**Consultation Response from KC,
Highways Development Management**
2026/91628 land off, Boshaw View, Hade Edge, Holmfirth, HD9 2TZ
Erection of 17 dwellings (Use Class C3) together with associated development including access, landscaping, ancillary infrastructure, and parking
Date Responded: 06/08/2026
Responding Officer: Ryan Kinder
Responding Ref: K3-43/6

2026/91628 Land at Dunford Road, Hade Edge.

RECOMMENDATION: Objection – further information required.

Site Layout Plan

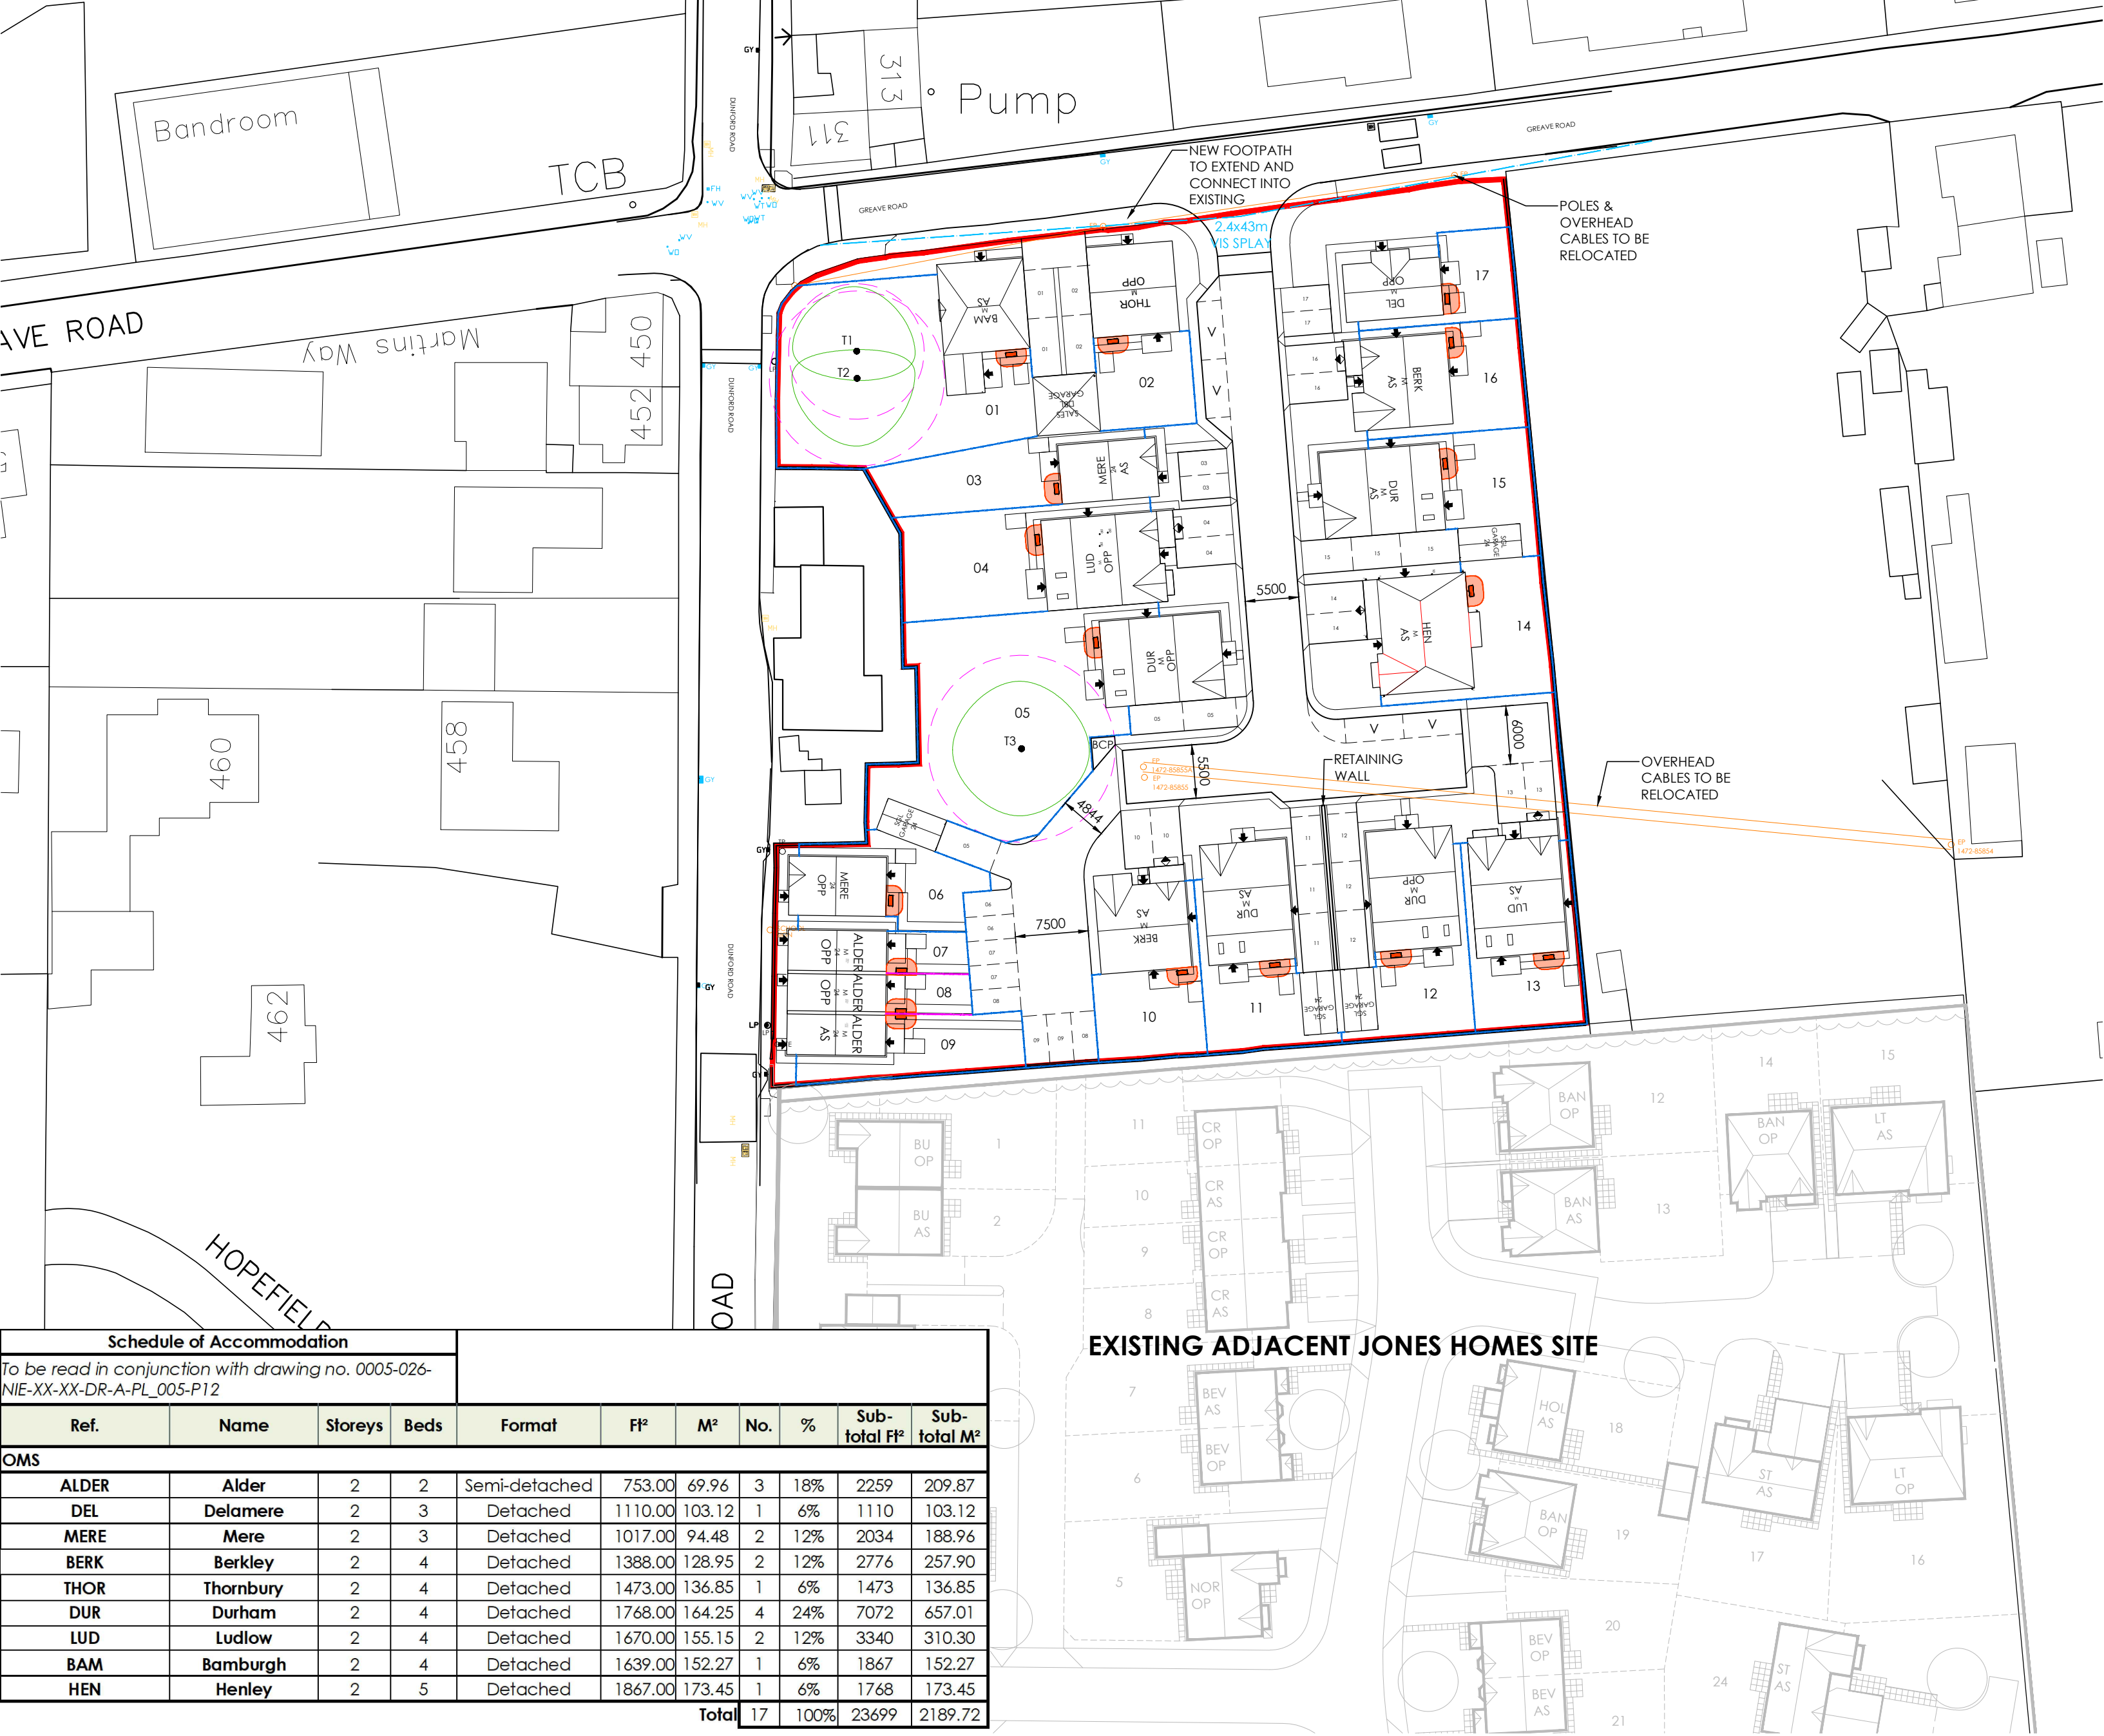
The site access is proposed to be taken via new opening onto Greave Road with a priority giveway arrangement. Suitable visibility has been demonstrated and considered acceptable. Swept paths for an 11.85m refuse collection vehicle have been provided, however there are concerns regarding this arrangement, given the width of Greave Road this manoeuvre is not possible without utilising the full width of the carriageway. In addition, if parked vehicles were opposite the site access then this would not be possible at all. HDM consider that access to the site should be taken via the existing development know as Boshaw View as per the application (2026/91628). Concerns are raised regarding the proposed access arrangement in its current form.

The internal road layout should be designed to adoptable standards and in line with the Councils SPD highway design guide. The current proposal indicates a 'traditional estate road for the access and bell mouth then onto a shared surface and private driveways. There are no long sections or finished gradients indicated on the submissions, for a shared surface arrangement the gradient must not be steeper than 1:20 otherwise a footway down both sides is required. Further clarification on this matter is therefore requested.

The internal layout should also provide an adopted road up to the boundary of the remaining parcel of safeguarded land to the east of the site to ensure this area is suitable for development in the future.

Forward visibility envelopes and junction sightlines should be indicated and achievable within the Highway boundary, it appears these are not indicated at the shared surface area of the site.

The proposed parking provision design for some properties appears to fall short of the design requirements. Where no segregated pedestrian access is provided for each property the width of the parking bays should be increased from the standard 2.5m to allow an additional 0.9m width to accommodate pedestrians exiting vehicles and for wheelie bin access.

Visitor parking spaces are indicated, however a minimum of a 1.0m hard margin to the rear of these is required for exiting vehicles.
